From: Allan Brown 5762 <Allan.Brown.5762@northumbria.pnn.police.uk>
Sent: 03 March 2021 09:06
To: DC
Cc: Claire.Watts.9900
Subject: 21/00326/FU4 Granny Annies

It will be the intention of Northumbria Police to comment by the 17th March, but firstly I am seeking clarification regarding the planning status and extent of the site that falls under the ownership of the Applicant. Could you confirm please the following:

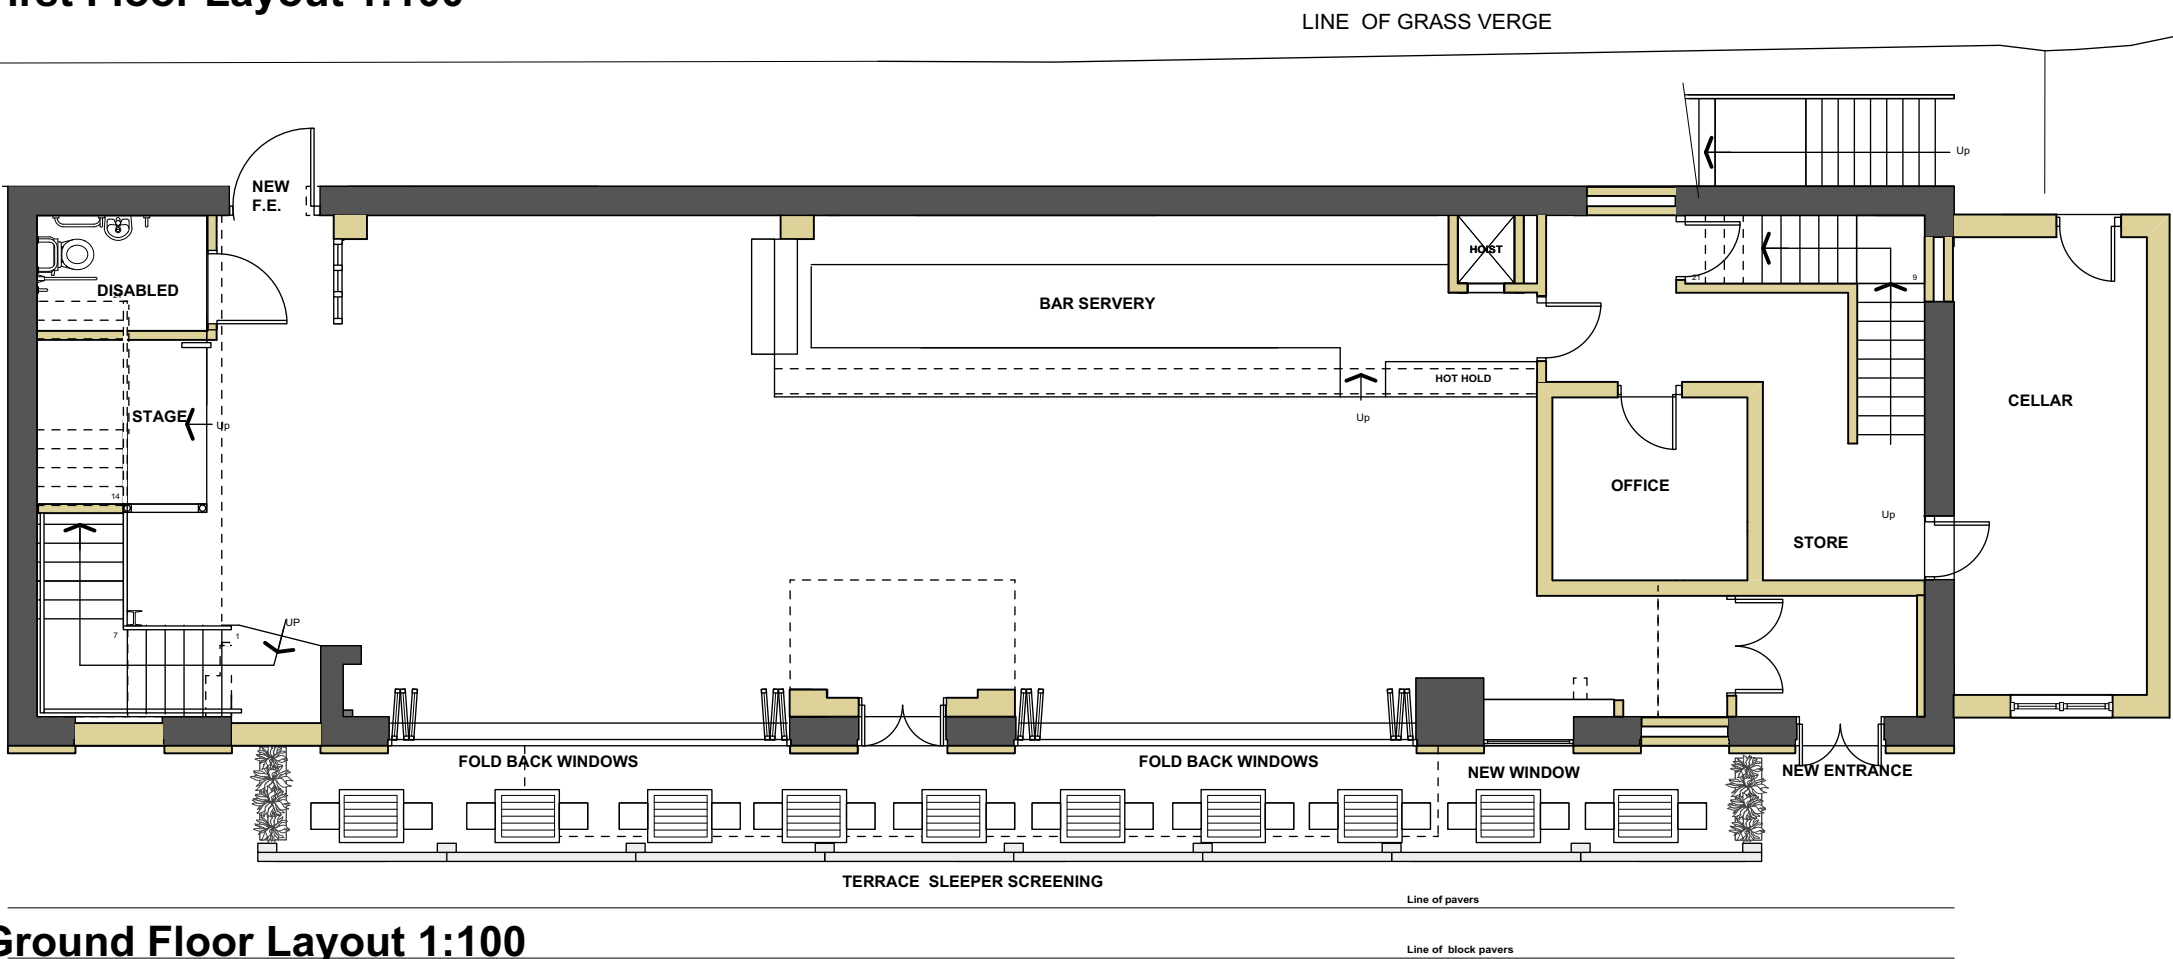
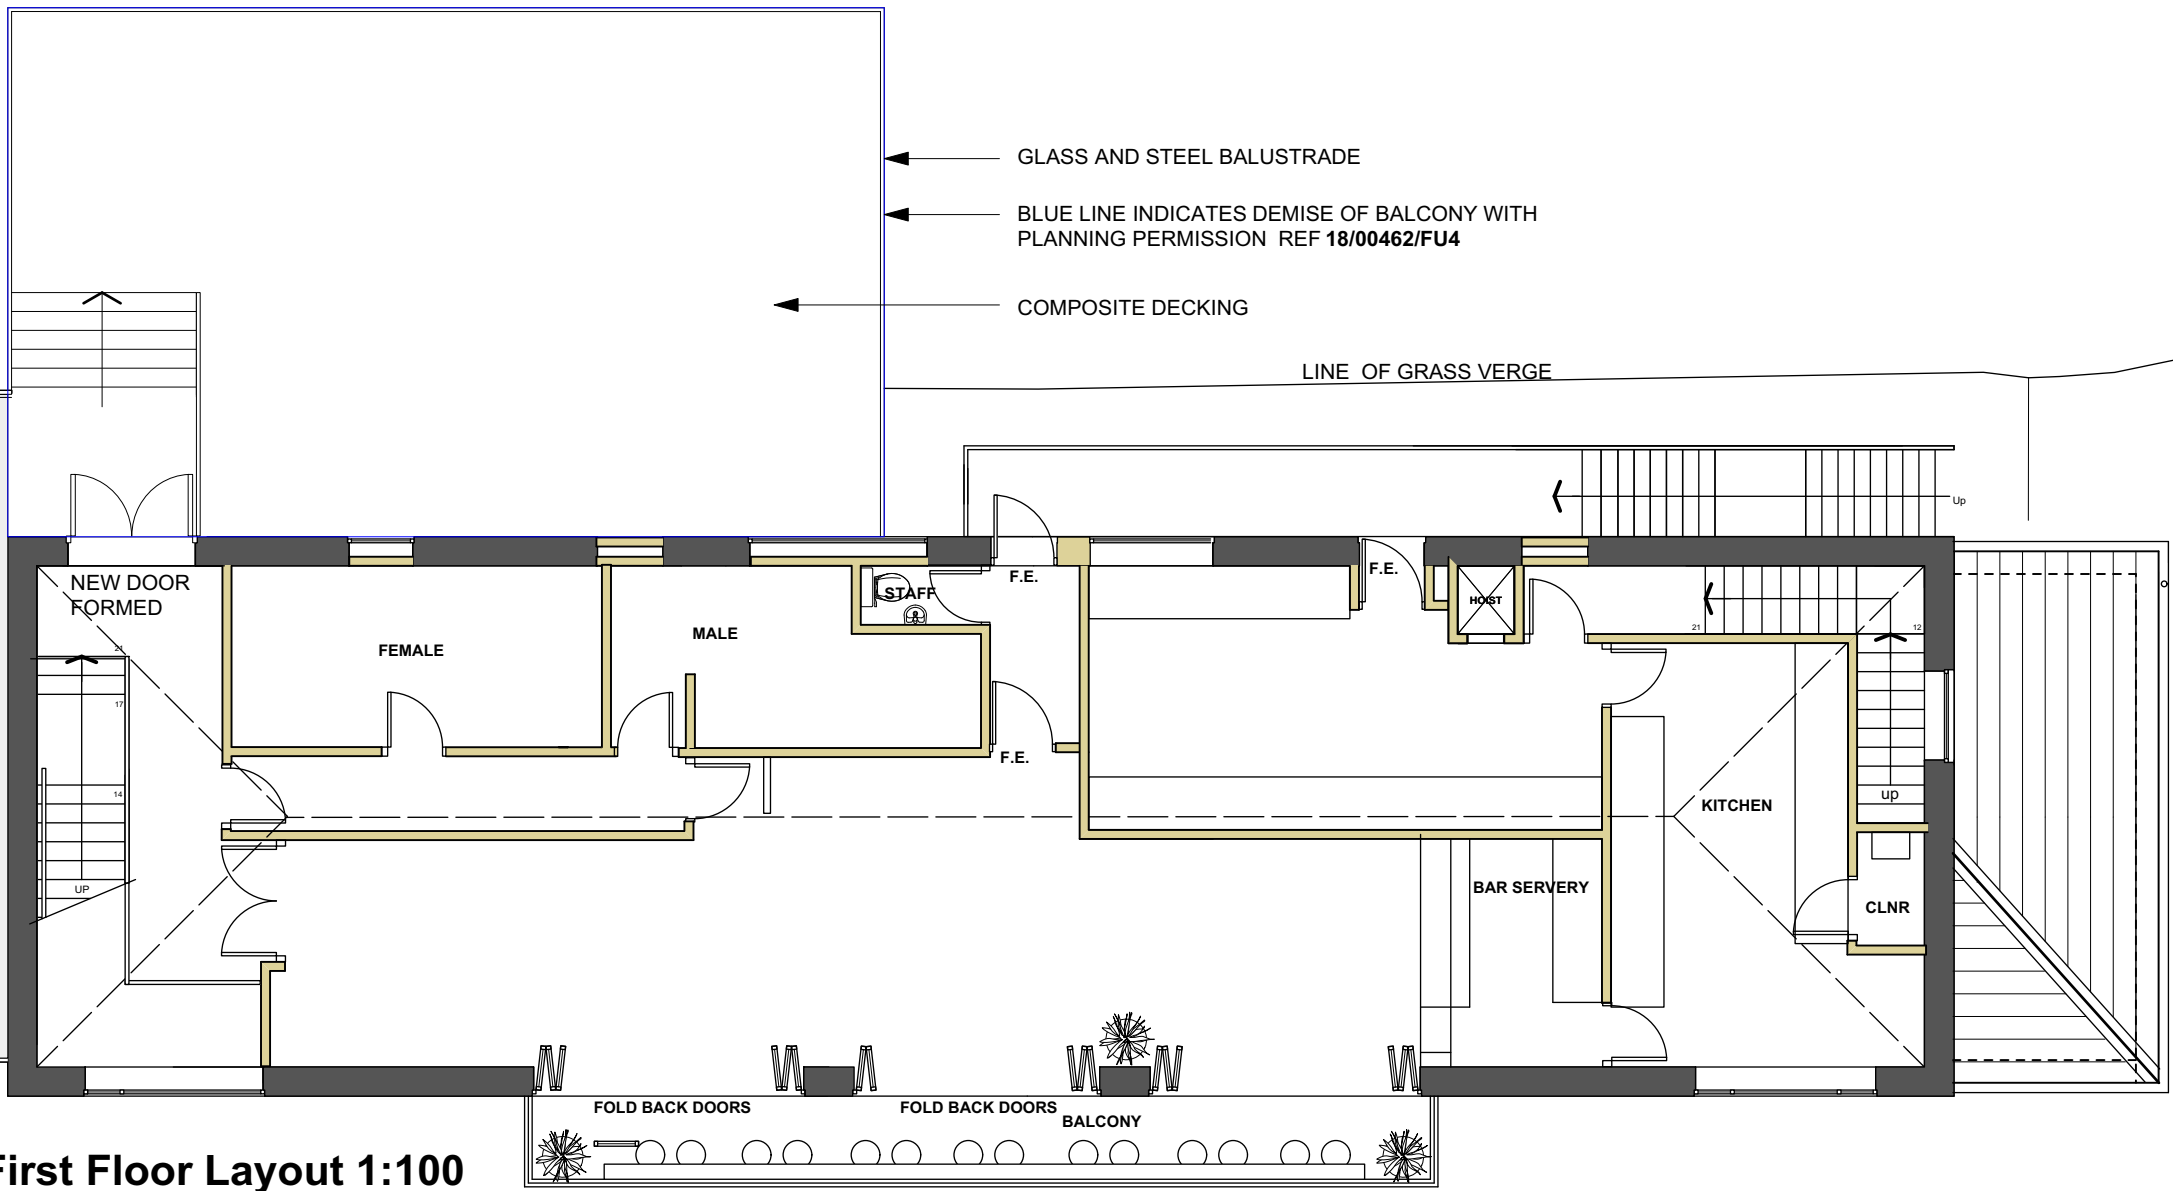
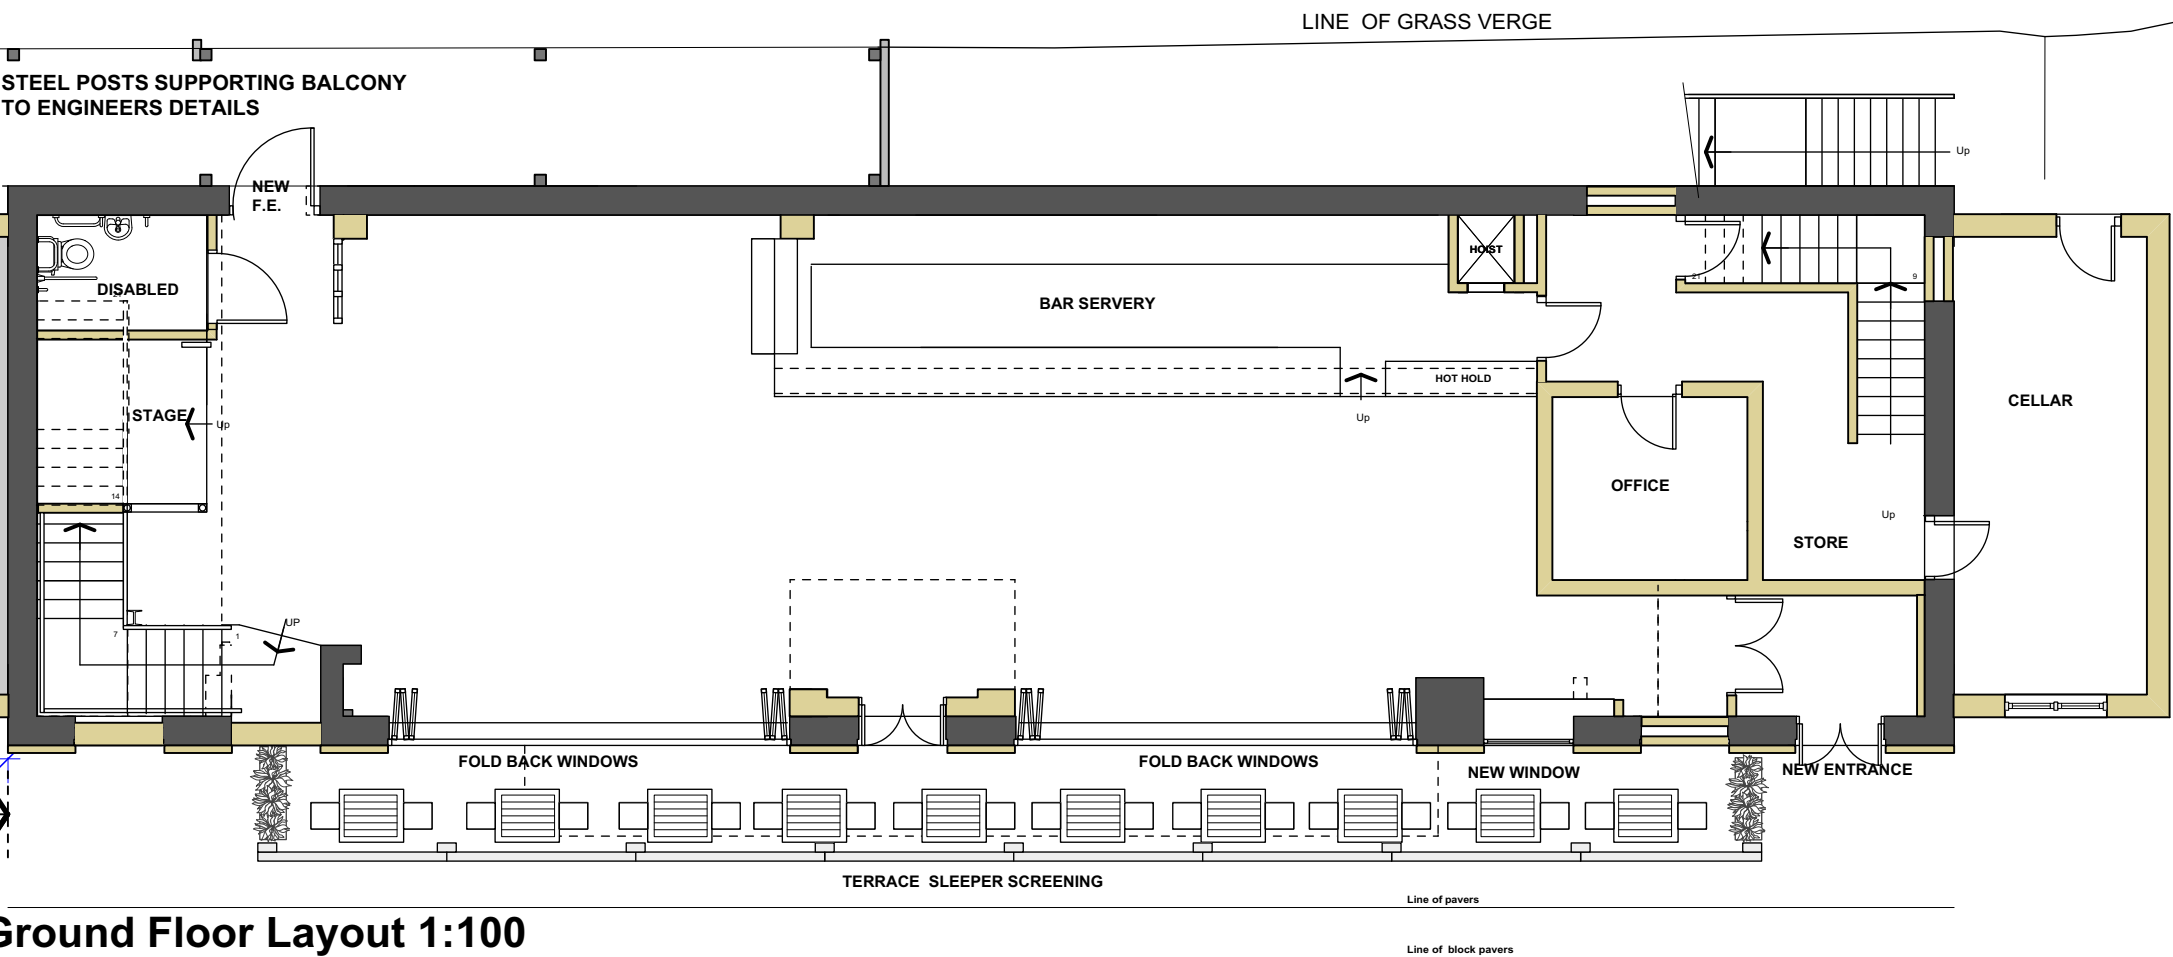
4. I note that drawing GA-21-04 suggests the demise of the previous balcony subject to planning permission REF 18/00462/FU4. Can you confirm that this balcony wasn't built and will not be pursued in the future?
